**Samuel Gilbert Public School Redevelopment (SSD 9274)
Cnr Ridgescrop Drive and Gilbert Road, Castle Hill
Notice of Exhibition**

Objective Reference: CD18/10798

TAB A – Detailed comments on SSD 9274

Figure 8 Additional kiss and drop zones (shown in red)

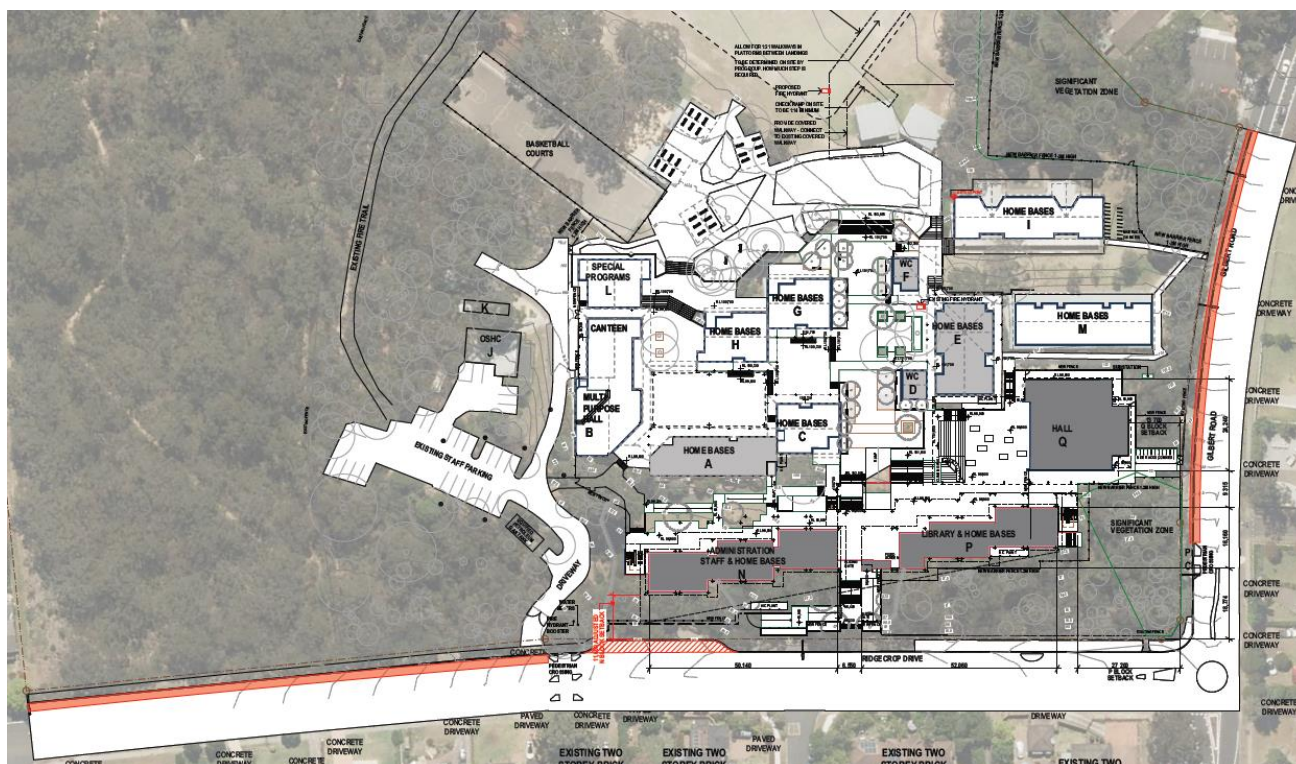
The above indicates that the current supply of ‘kiss-and-ride’ kerbside parking (approximately 32m of kerbside length) is insufficient for demand. Although the ‘shutdown’ of the indented bay would alleviate the blockage of the eastbound traveling lane, the demand for pick-up and drop-off would still be present albeit being undertaken elsewhere.

As described in Section 5.5 of the report, the kerbside parking restrictions available for private vehicles along the surrounding roads are primarily unrestricted, which indicates that there are no additional ‘kiss-and-ride’ opportunities currently available.

Additional assessment should be undertaken to determine an appropriate provision of ‘kiss-and-ride’ for the expected demand. It should be recognised that parents/guardians would have different preferences with regards to parking durations. The management of parking surrounding the school should balance the diverse demands of parents/guardians.
